From: Tim Murray [REDACTED]
Sent: 13 June 2018 15:34
To: Anita Gardner
Subject: RE: LY/5/18/PL - Pindars, Lyminster

From: Anita Gardner
Sent: 11 June 2018 10:48
To: [REDACTED]
Subject: LY/5/18/PL - Pindars, Lyminster

DRAWING PLANNING DATE: JANUARY 2018 DRAWN: T. Murray	SCALE 1/50
DRAWING: 18/04/2	REVISION:

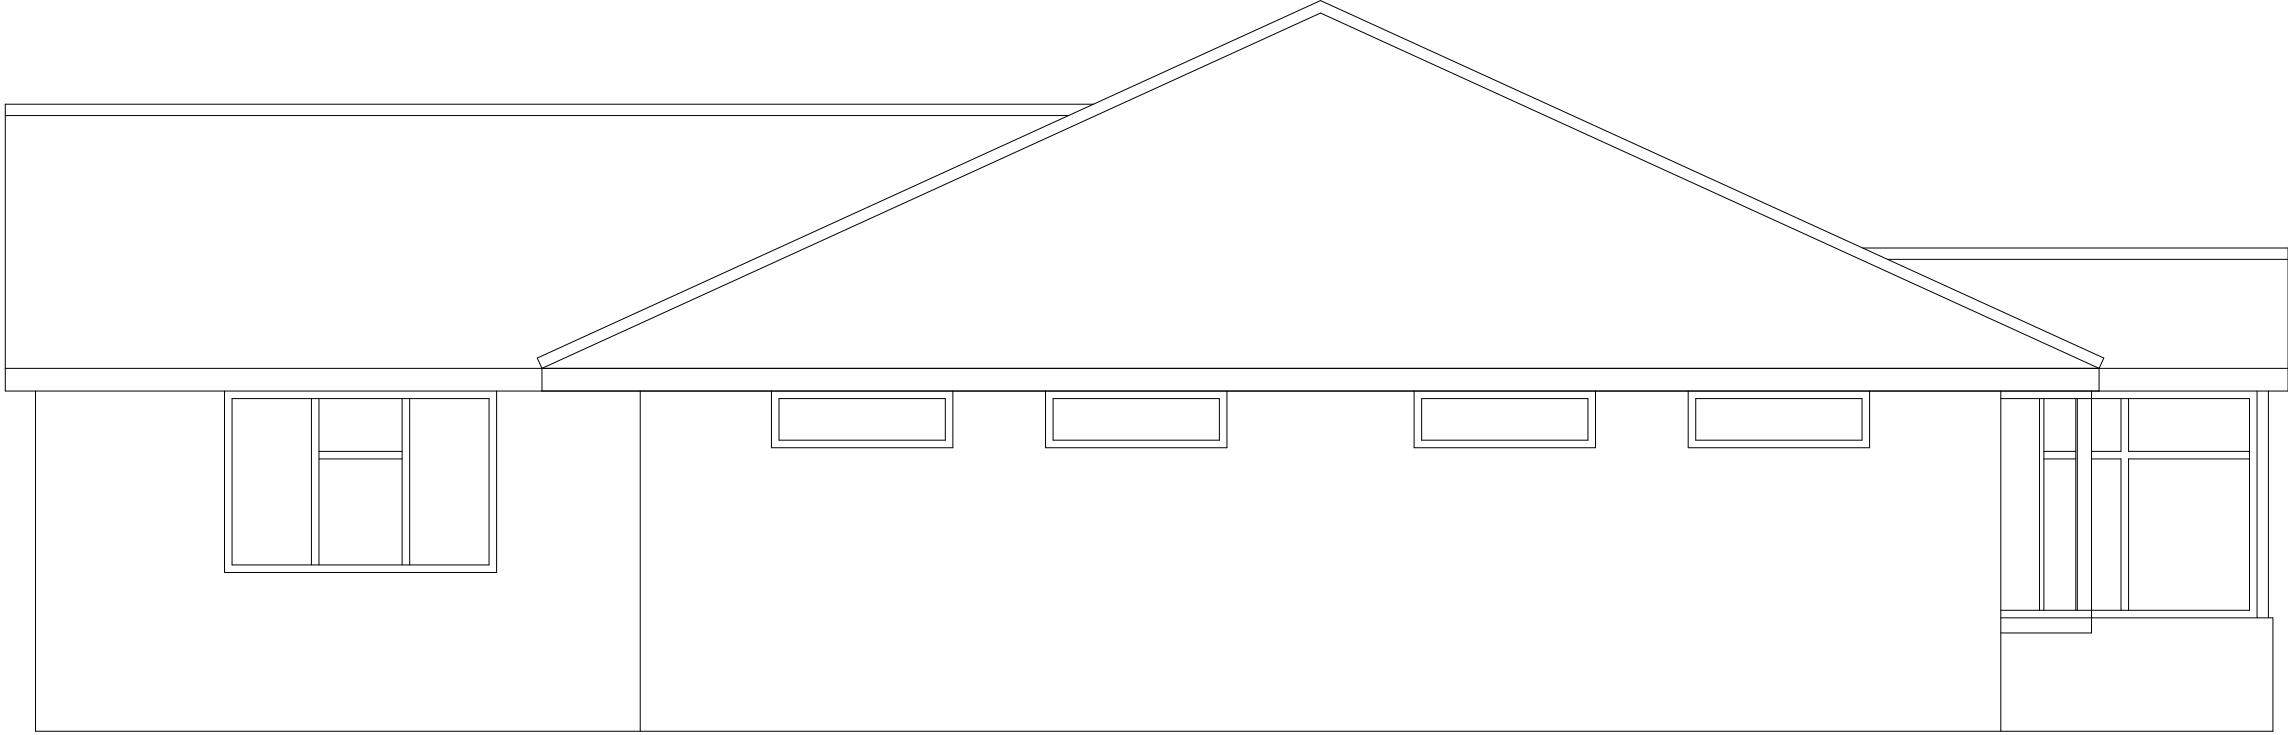
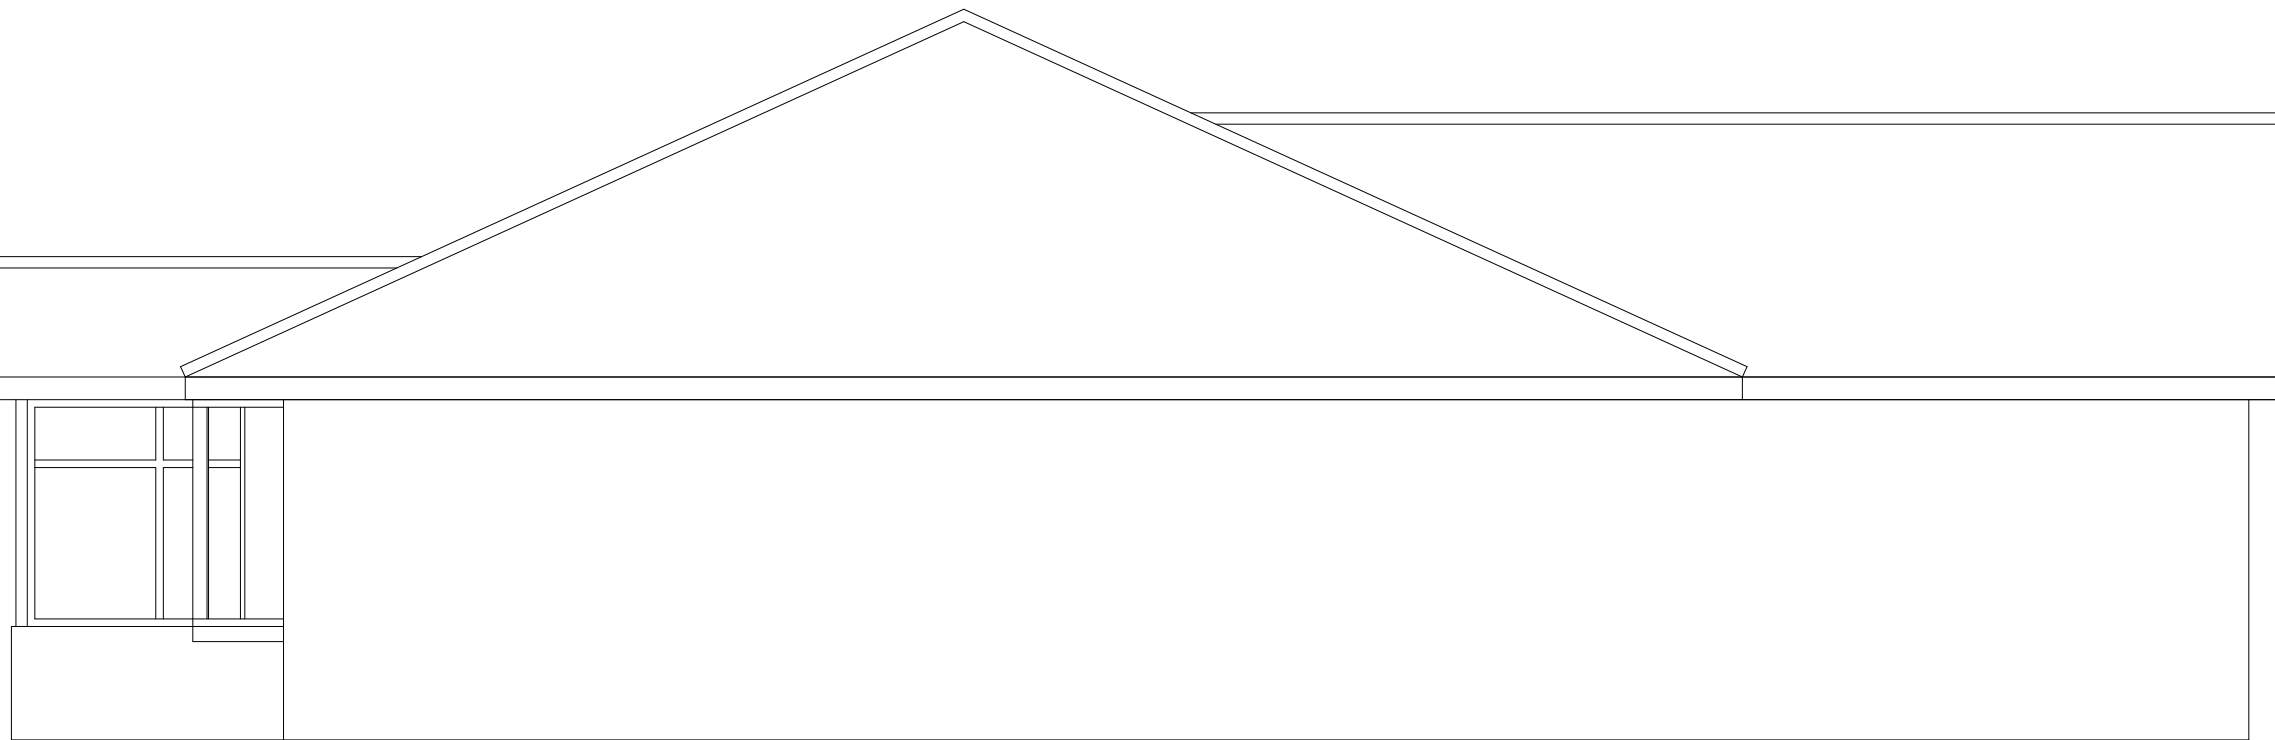
- We need an accurate streetscene drawing – the one submitted does not show accurate distances between the properties
- the elevation drawing is not sufficient to demonstrate it's a high quality design

DRAWING PROPOSED SITE PLAN DATE: JANUARY 2018 DRAWN: T. Murray	SCALE 1/500
DRAWING: 18/04/4	REVISION:

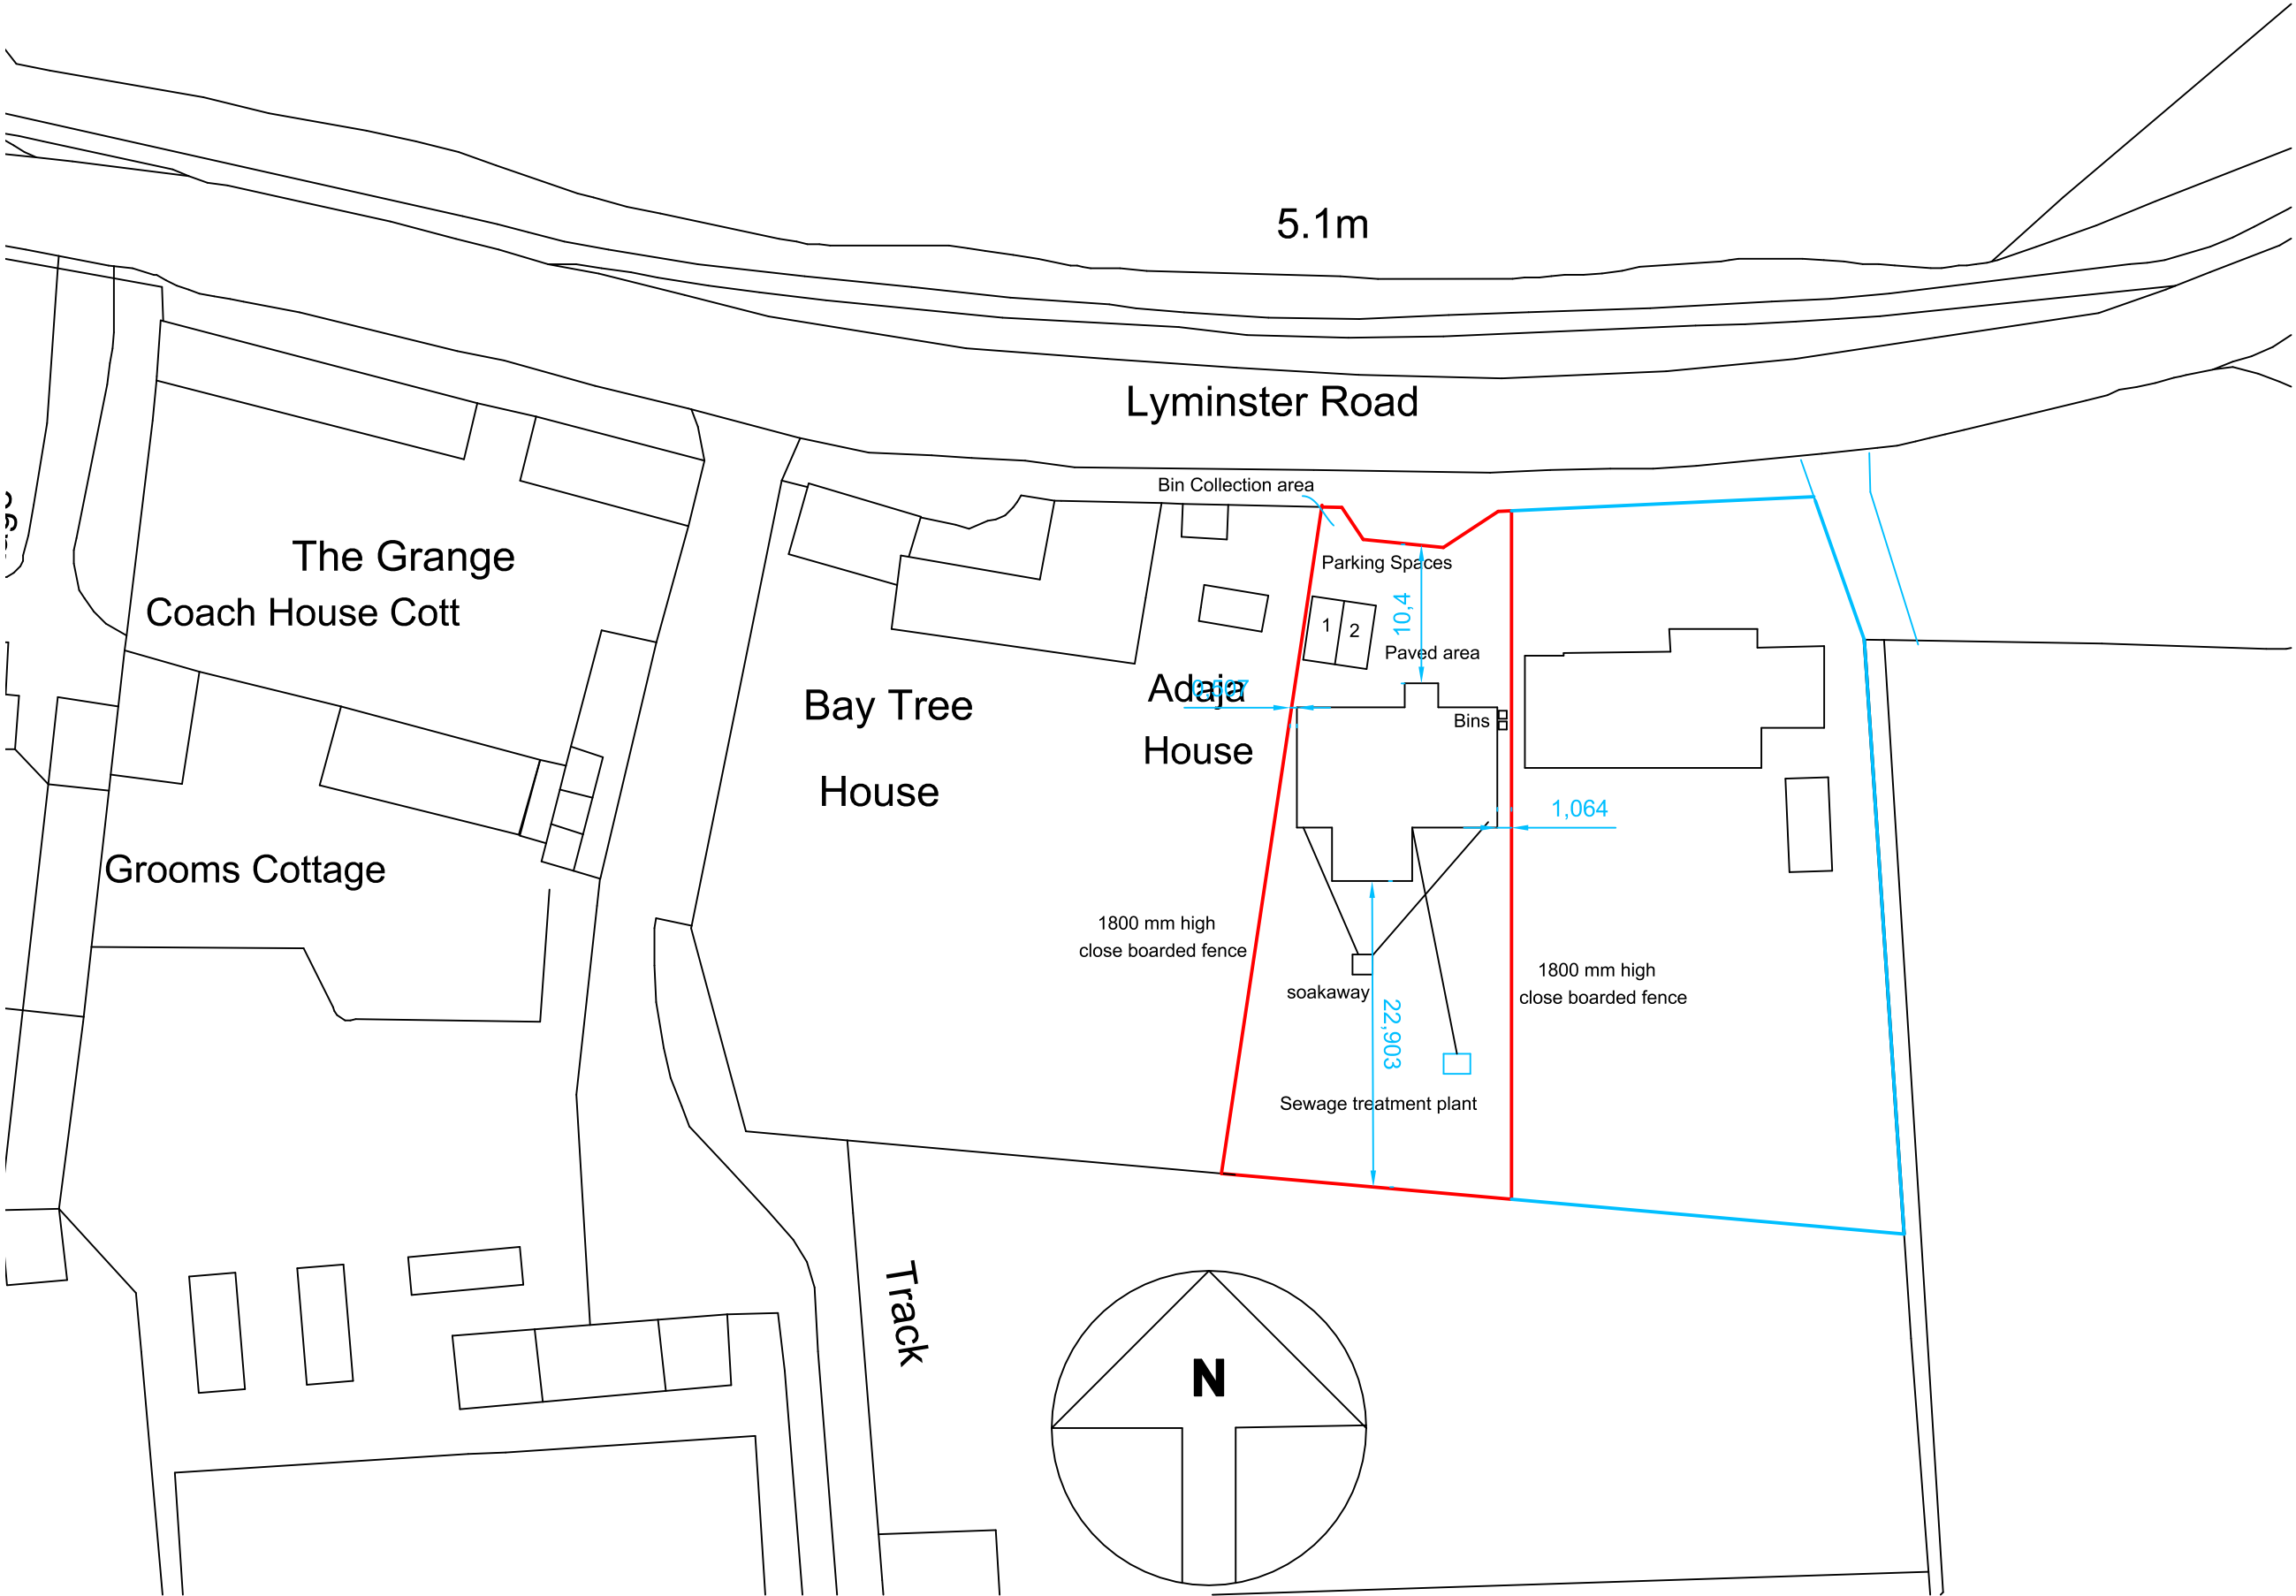
I have consulted County Highways and their comments are still awaited, but you may wish to consider demonstrating that there is adequate space to turn a vehicle before exiting the site or this could form a reason for refusal.
